RE: Tilbuster Solar Farm – SSD 9619 – Response to Submissions - Revised Biodiversity Development Assessment Report

Attachment 1: Detailed BCD Comments – Tilbuster Solar Farm (SSD – 9619) – Response to Submissions – Revised Biodiversity Development Assessment Report

Figure 9-1 Location of serious and irreversible impacts

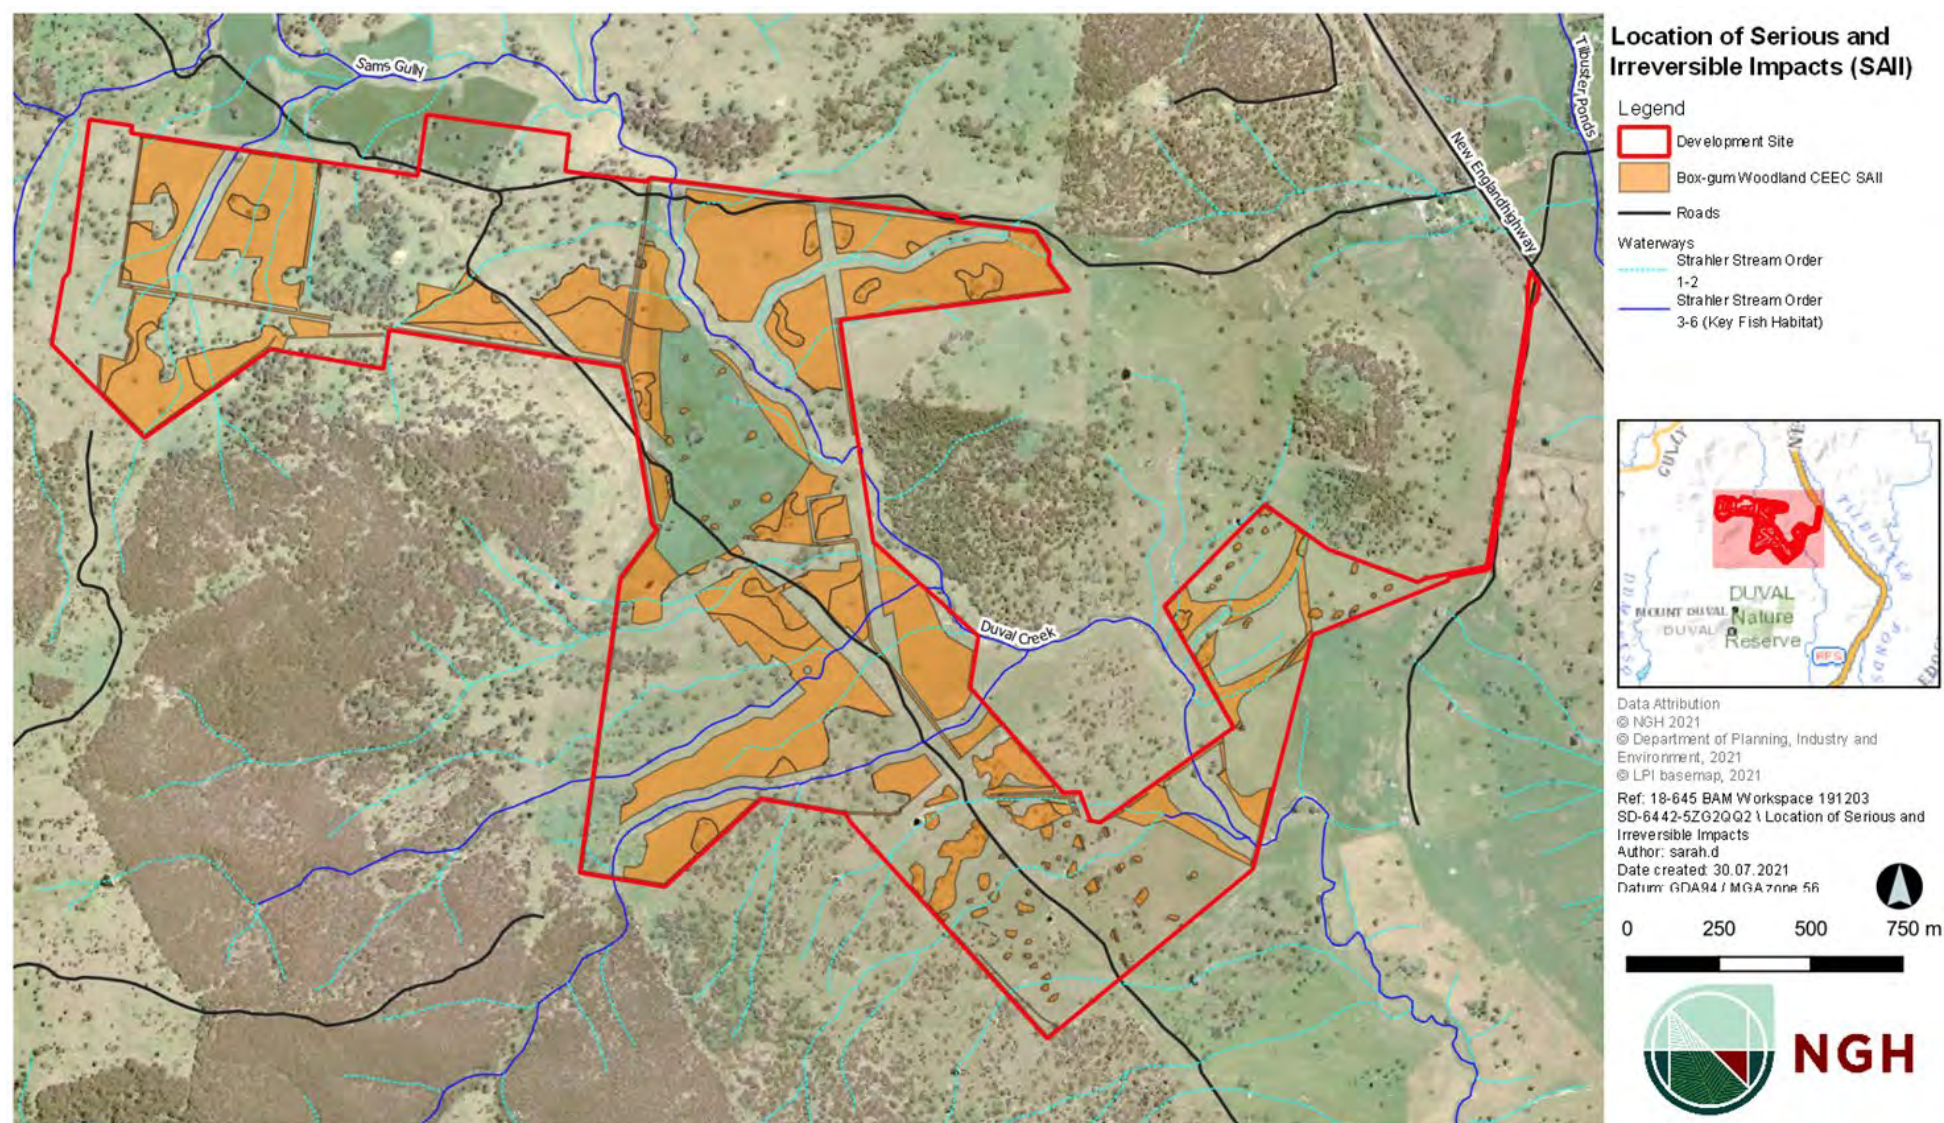
The development site contains 71.1 ha of this critically endangered ecological community as a woodland with very high vegetation integrity and the proposal involves clearing 23.2ha of this, comprising 33% of the highest quality woodland on the site.

Based on the above analysis, the BCD concludes that it is likely the proposal will have a Serious and Irreversible Impact on the critically endangered White Box Yellow Box Blakely's Red Gum Woodland ecological community.

11. If the consent authority determines that it is likely the proposal will have a Serious and Irreversible Impact, then additional and appropriate measures must be developed and adopted, as per Section 7.16(3) of the BC Act, to minimise the Serious and Irreversible Impacts of the development on this CEEC, which could include:

- a. modifying the proposal to further avoid impacts on Vegetation Zones 1 and 5 by reducing the development footprint to avoid these areas of the critically endangered White Box Yellow Box Blakely's Red Gum Woodland ecological community; and
